Item No. **Report of the Interim Director of Planning, Regeneration & Public Realm**

Address 60 LONG LANE ICKENHAM MIDDLESEX

Development: Demolition of existing dwelling and erection of two storey detached building with habitable roof space to provide 8 x 2-bed flats and 1 studio flat with associated amenity space and parking.

LBH Ref Nos: **70282/APP/2022/1143**

SOUTH EAST ELEVATION

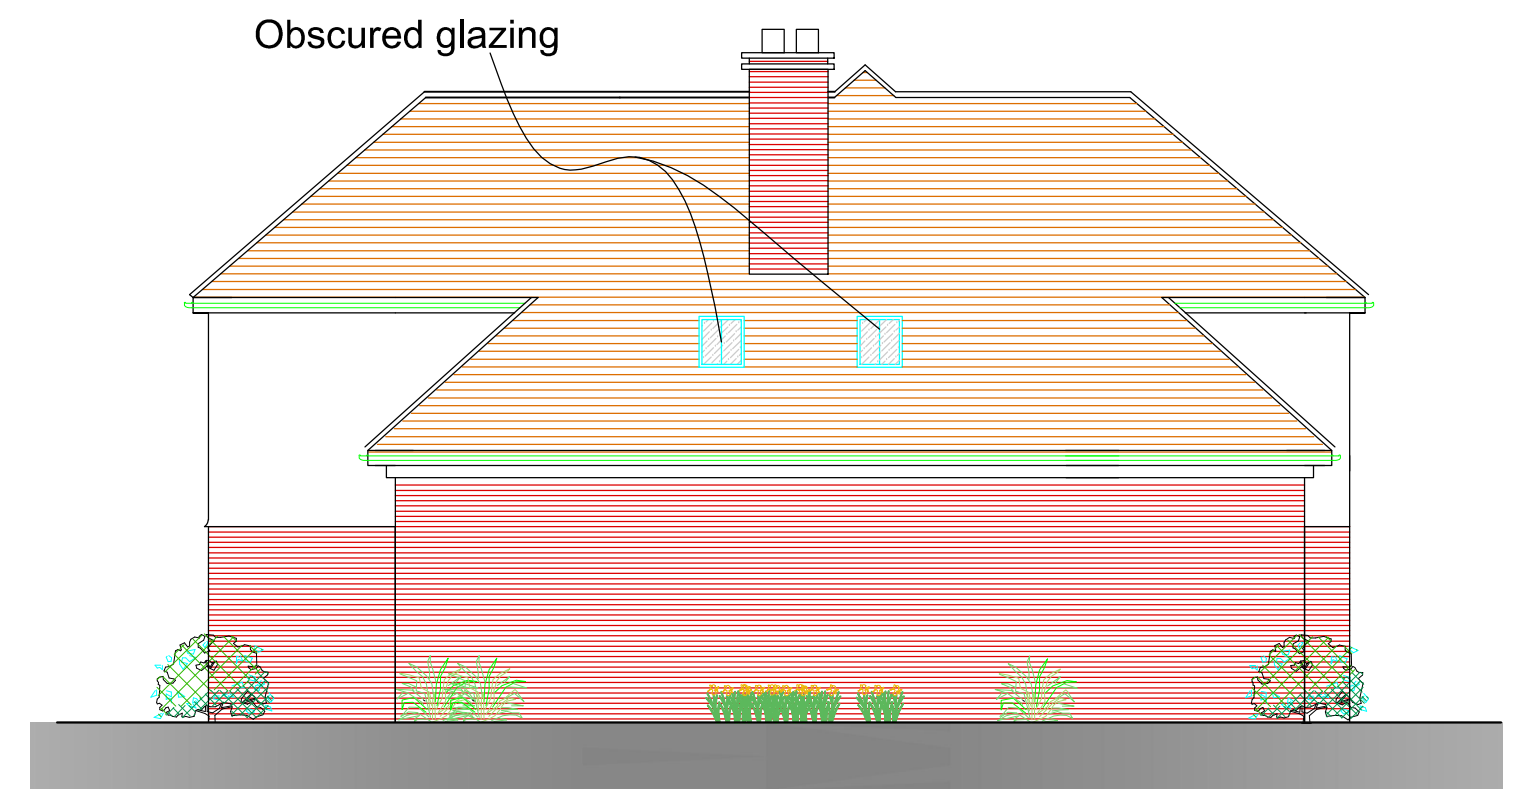
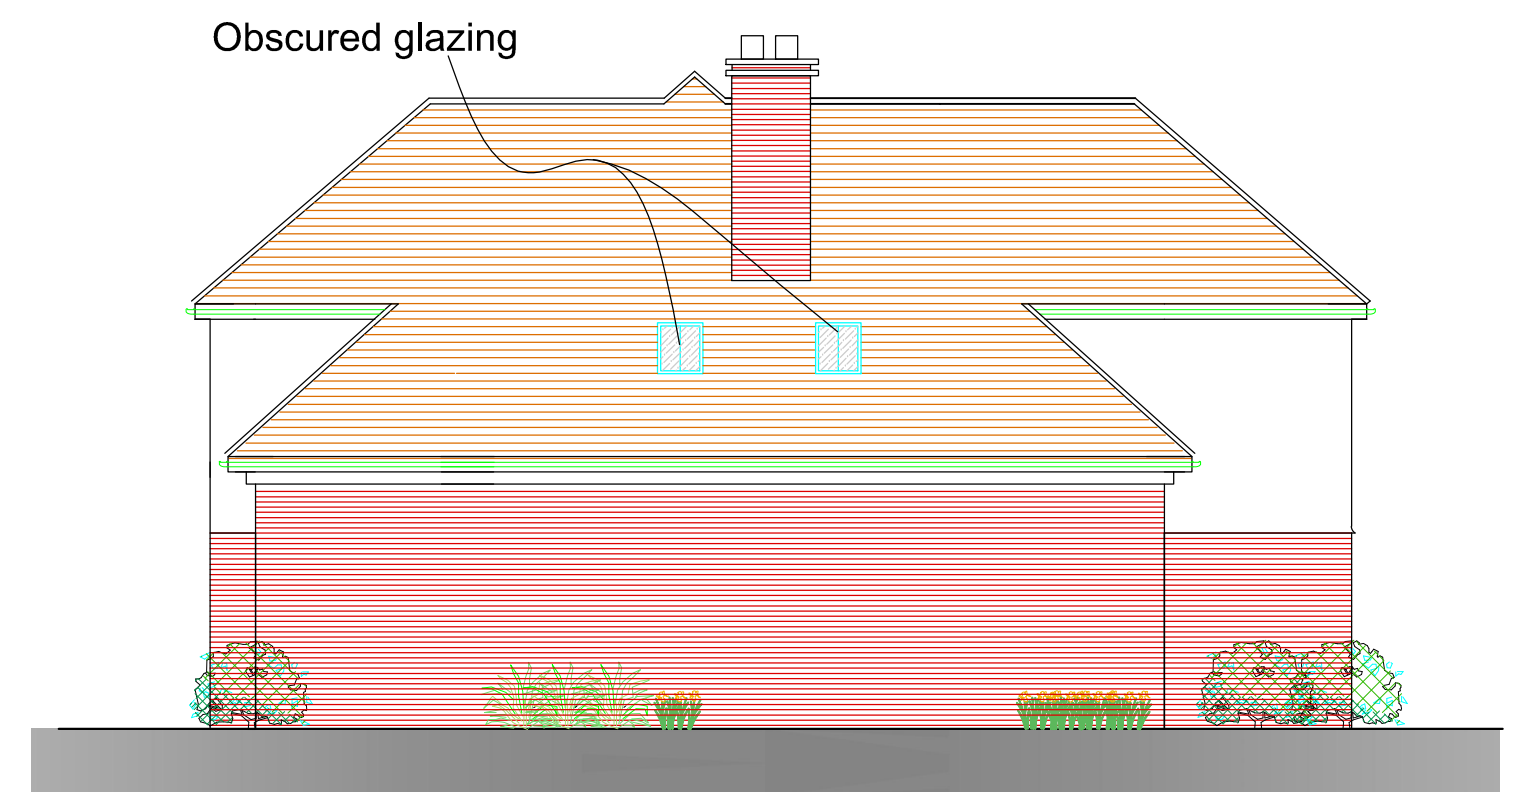
The proposed development, by reason of its size, scale, massing and design (including its uncharacteristic crown roof profile and lack of detail in respect to the height of the proposed sky lights) , would fail to harmonise with the character and architectural composition of the surrounding properties, appearing as a visually dominant, incongruous and bulky form of development which would be detrimental to the visual amenity of the street scene and would neither preserve or enhance but harm the character and appearance of the surrounding Conservation Area. The proposal therefore conflicts with Policies BE1 and HE1 of the Hillingdon Local Plan: Part One- Strategic Policies (2012) and Policies DMHB 1, DMHB 4, DMHB 11 and DMHB 12 of the Hillingdon Local Plan: Part 2 - Development Management Policies (2020), Policies HC1, D3 and D4 of the London Plan (2021) and the National Planning Policy Framework (2021).

4.5. Crown roof elements are not an established feature in the conservation area and tend

to indicate that the development is too deep. Well-designed new builds should be able to avoid the need for crown roof elements.

LOFT PLAN

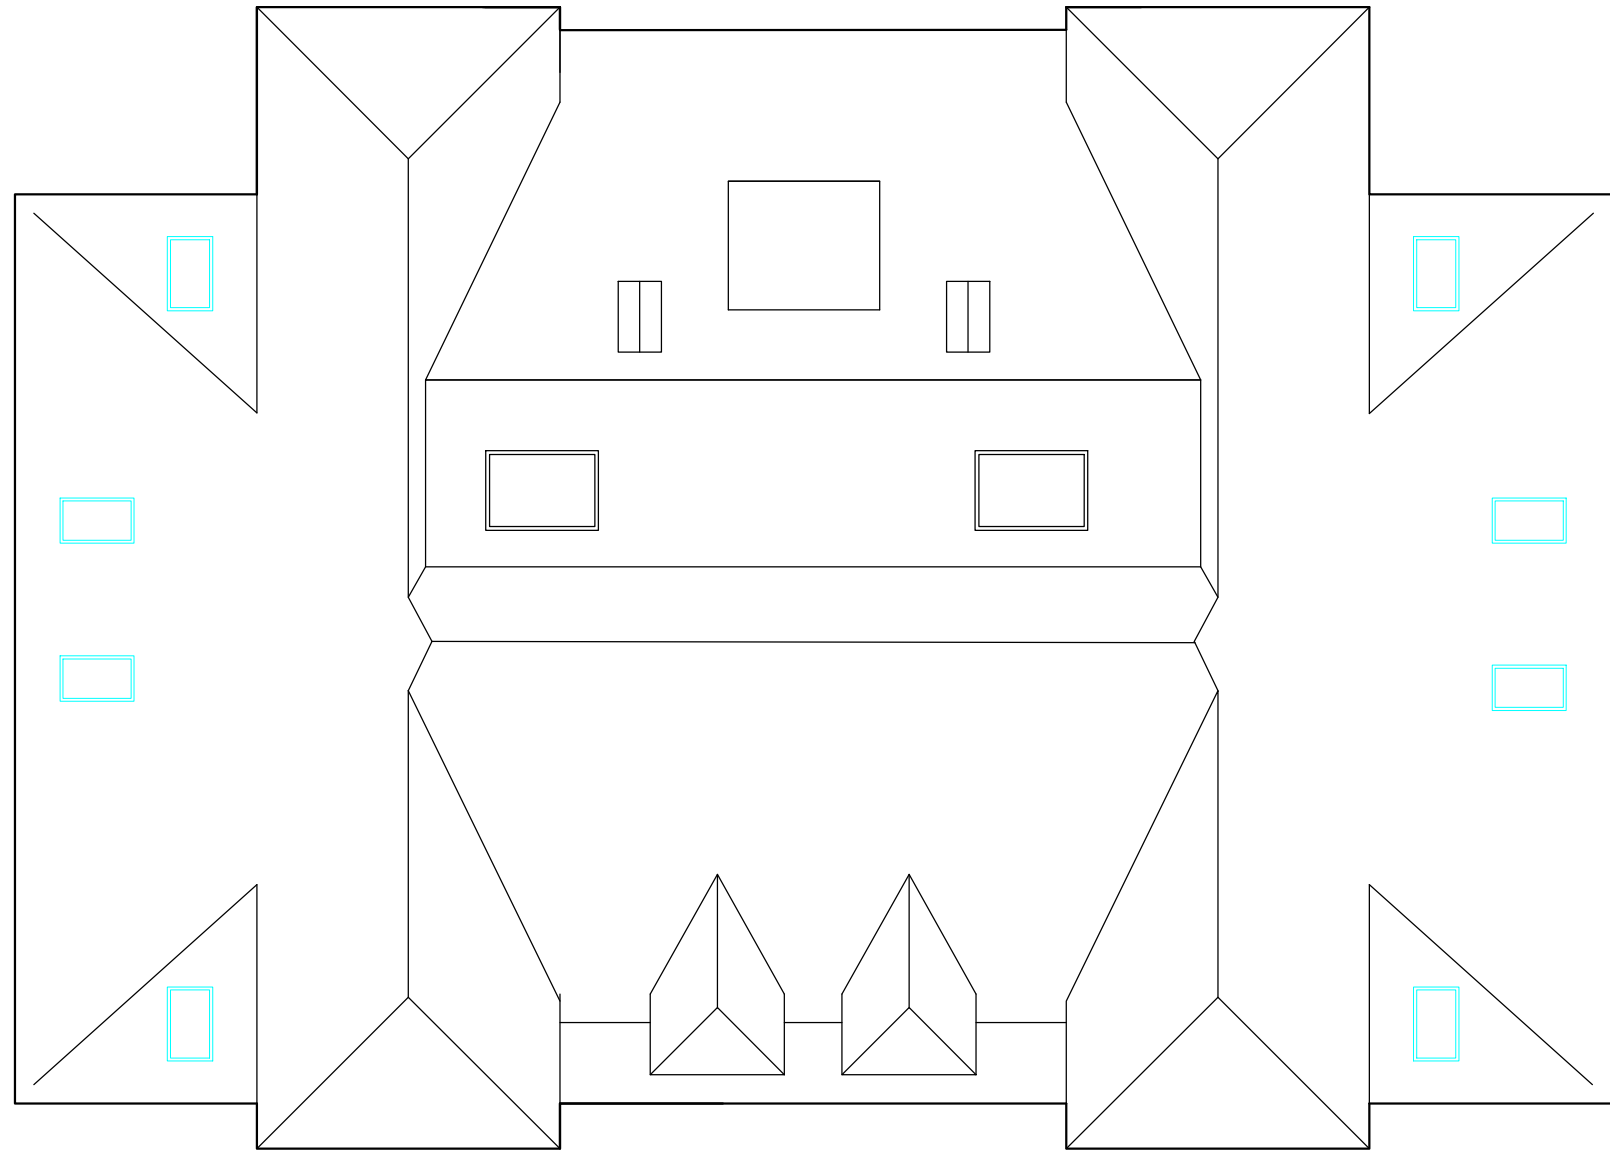
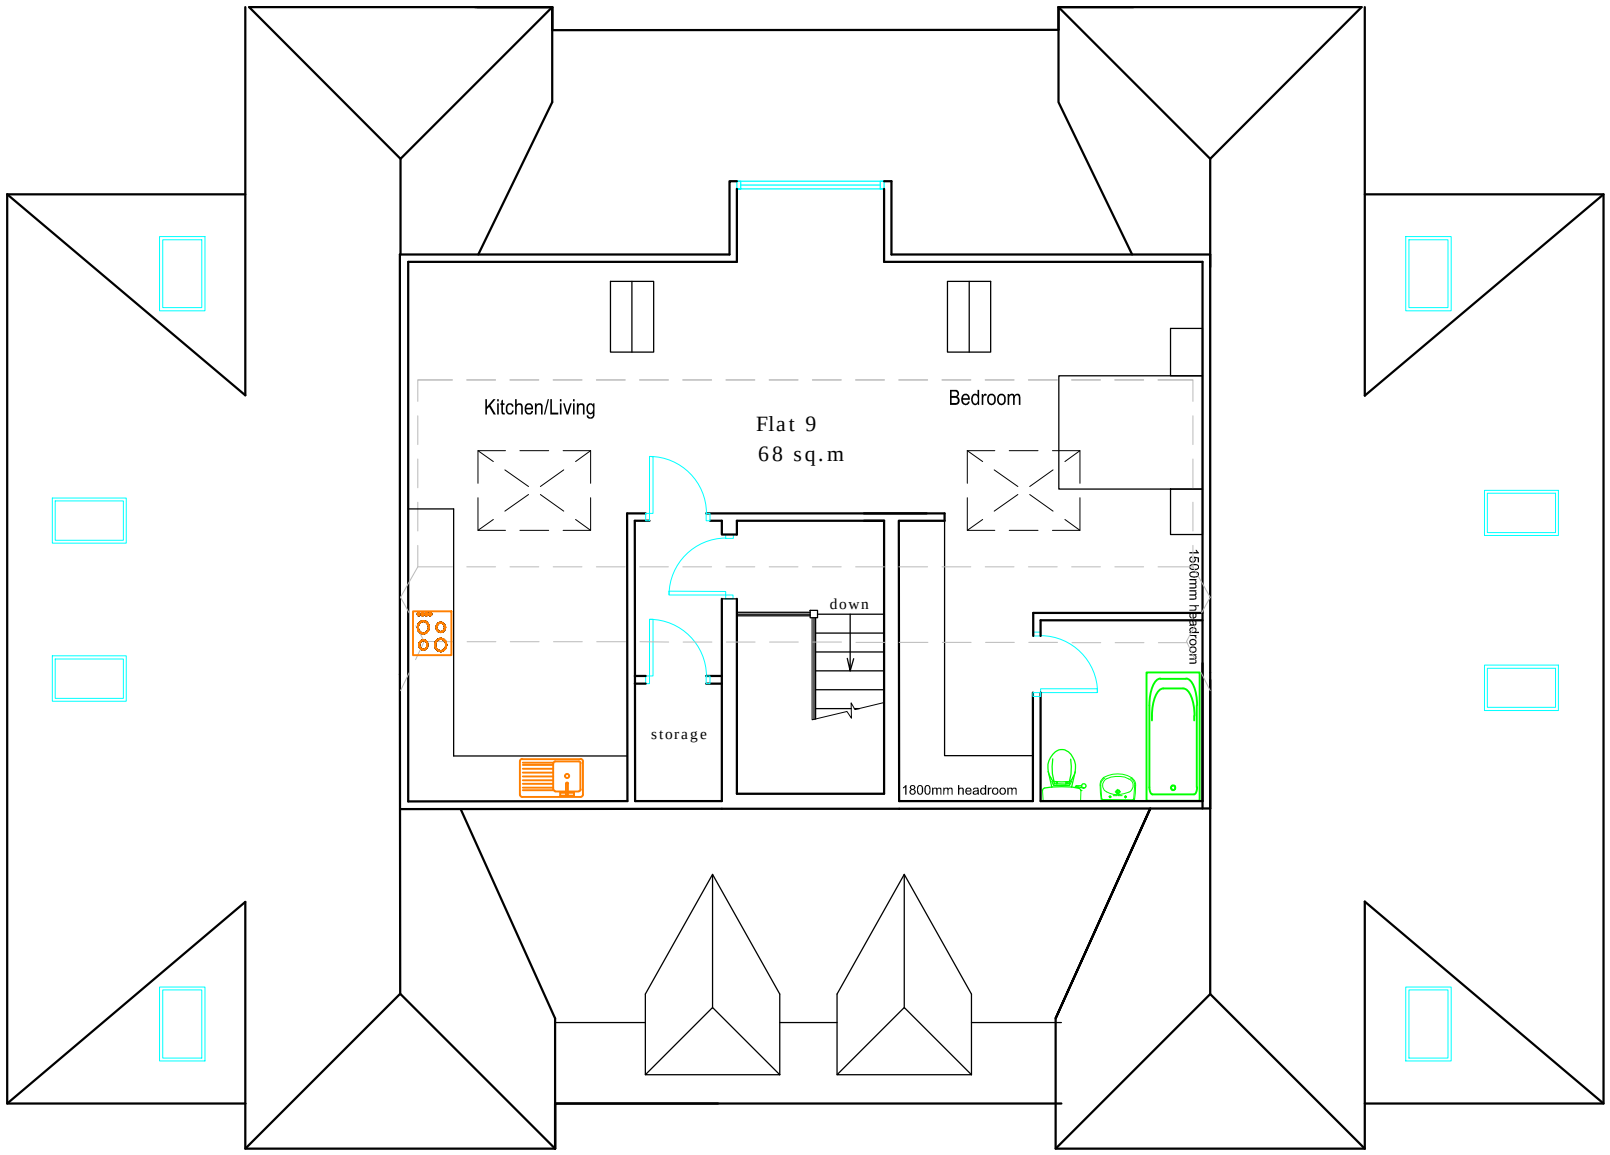
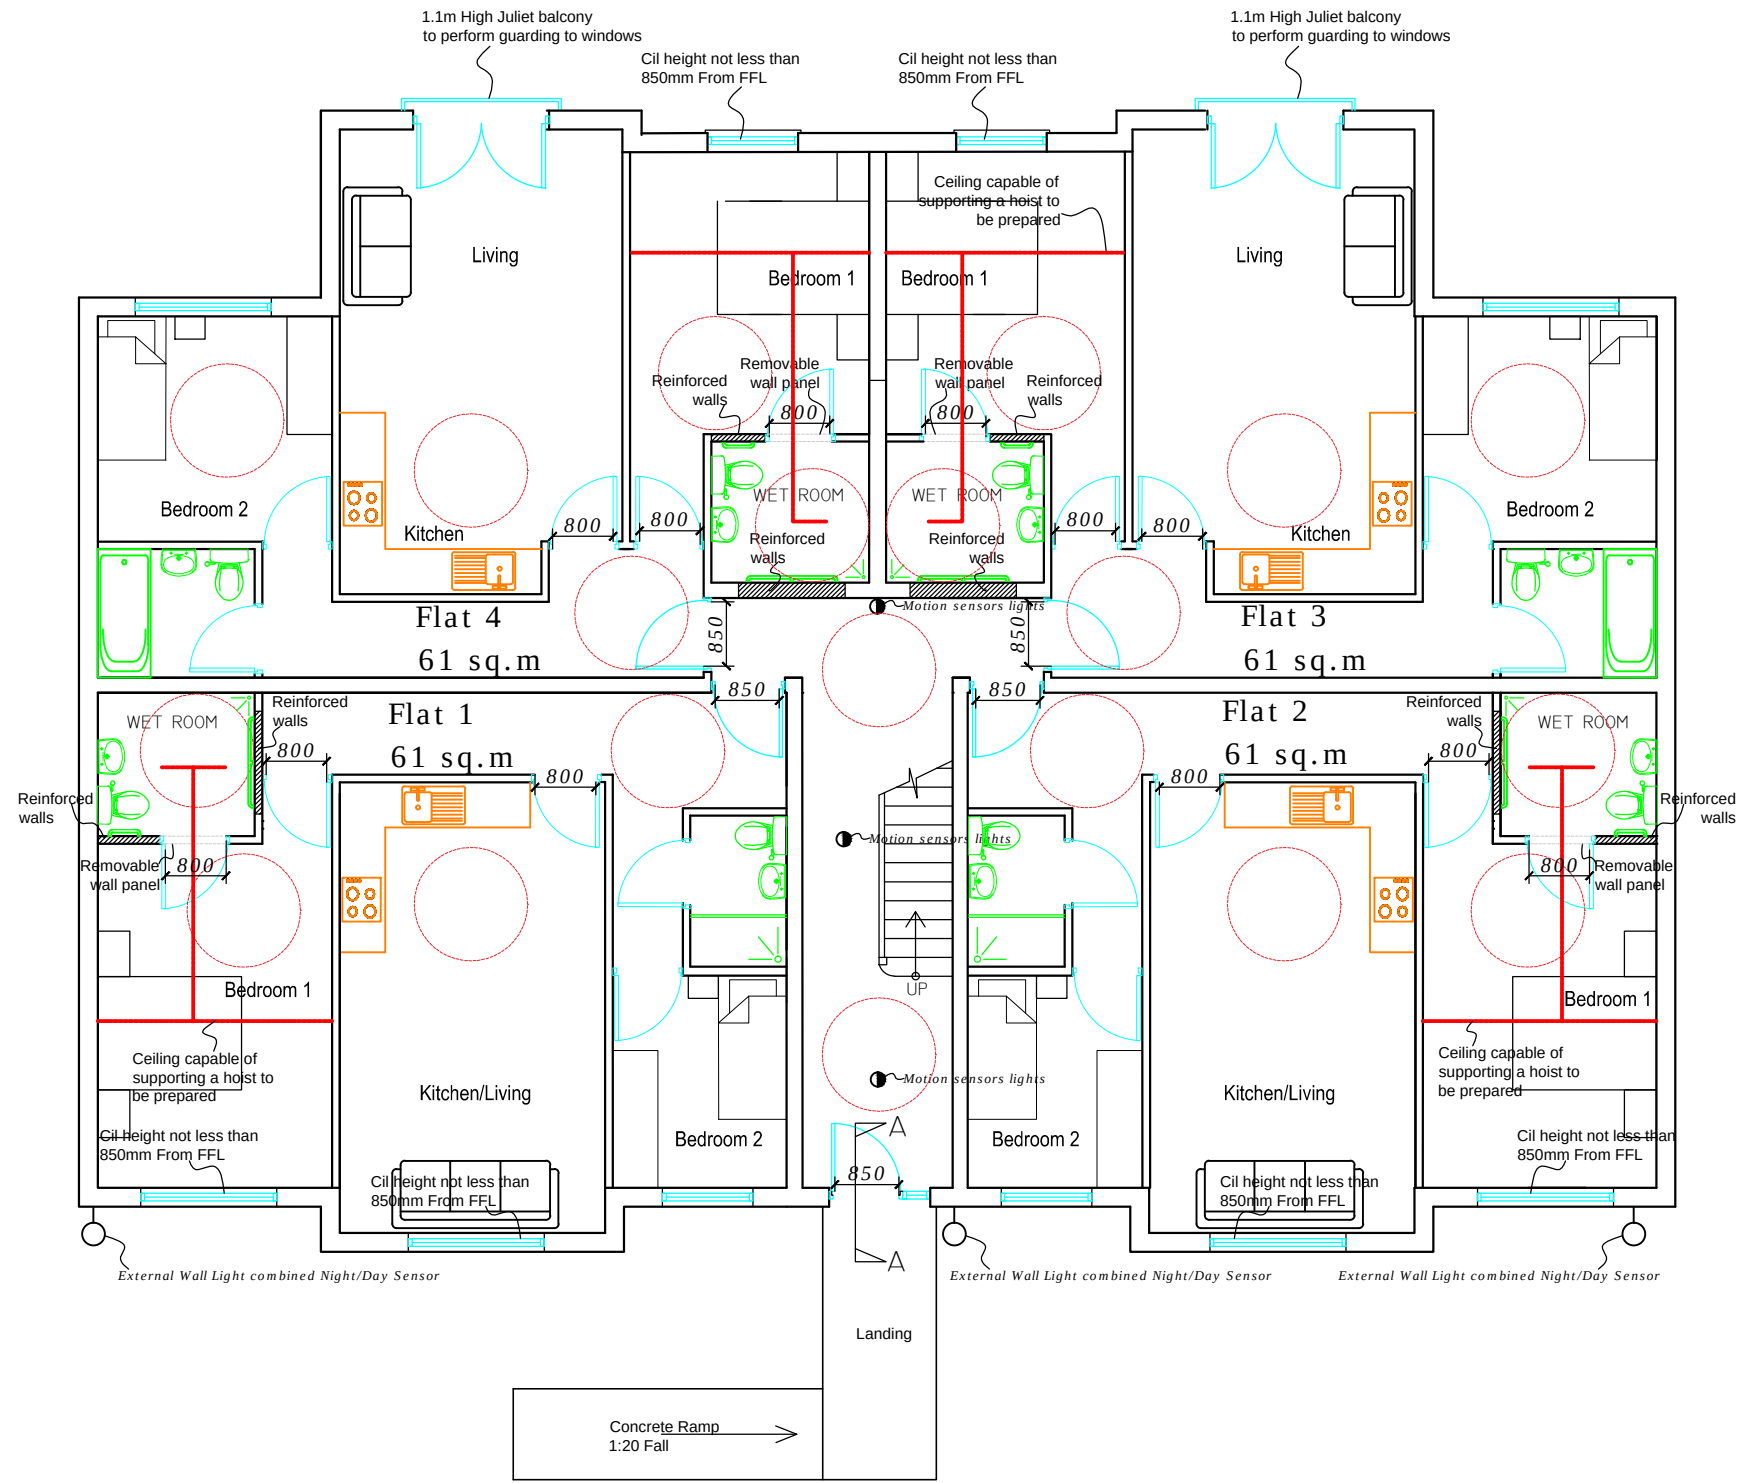
The proposed development, by virtue of the internal layout of the loft space and position of the proposed rear dormer, skylights and roof lights, would result in poor outlook and an oppressive living environment for the future occupiers of Flat 9. The proposal would therefore result in substandard forms of residential accommodation to the detriment of the amenity of future occupants of the proposed development, contrary to Policy DMHB 16 of the Hillingdon Local Plan: Part Two - Development Management Policies (2020), Policy D6 of the London Plan (2021) and the National Planning Policy Framework (2021).

4.6. There would be significant concerns in terms of the quality of the Flat 9 within the roof space, with outlook limited to 2 rooflights and a dormer window.
